DEVELOPMENT FACILITATION TEAM (DFT) MEETING AGENDA

July 2, 2025

| Project No: PR-2020-003688 | Date: 7/02/2025 | Agenda Item: #11 | Zone Atlas Page: J-10 |

Application For: PA-2025-00184 - SKETCH

SUBDIVISION PLAT OF
LOT A-I, TRACT A, LOT 50-A & 51-A
DAVIS-PEREA-COURSON SUB

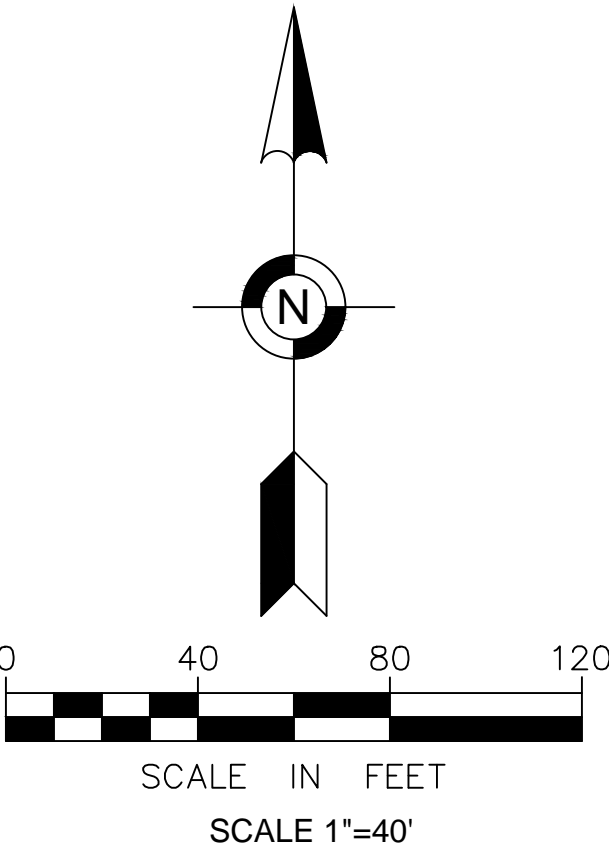
1. A Request for Availability (250609) has been received and will provide conditions for service.
 - a. Please note there is a previous letter (200905) that provided conditions for a similar subdivision and requirements may be very similar however if any changes have taken place please elaborate.
2. It is not clear the plat boundary. Please ensure this is clearly delineated.
3. Please label all existing and proposed lots. It is not clear if lot 51-a is existing as well as lot 50-a.
4. For this plat, coordination with Utility Development will be required and a utility plan will need to be reviewed prior to any approvals to ensure the utility plan acquires adequate easements for the public infrastructure needed for the site.
5. Add the following note on the plat when easements are being granted for public water and/or public sanitary sewer infrastructure.

1. Coors is a Principal Arterial and a Major Transit Corridor and requires 6' to 10' sidewalks with a 6' to 8' landscape buffer. Daytona, Cloudcroft and 62nd are local roads and require 5' sidewalks with 4' to 6' landscape buffers. Please provide dimensions of existing sidewalks and buffers to determine if widening or construction is needed.
2. 62nd will need to be constructed along all frontages including roadway, curb, gutter and sidewalk.
3. All work in the ROW will need to be on an infrastructure list and be completed through work order.

- Demonstrate compliance with Section 7 of the **DPM, Table 7.2.29**, regarding Sidewalk width requirements and its landscape buffer. Coors Boulevard is considered a Principal Arterial Street in the Long-Range Roadway System (LRRS). This type of street requires a 6ft sidewalk width and a 5-6ft landscape buffer.

- The applicant has included a drawing in the submitted packet that shows that there will be a 5' storm easement, a 22' access, storm and utility easement and a 5' utility easement (lot I) granted by this plat.
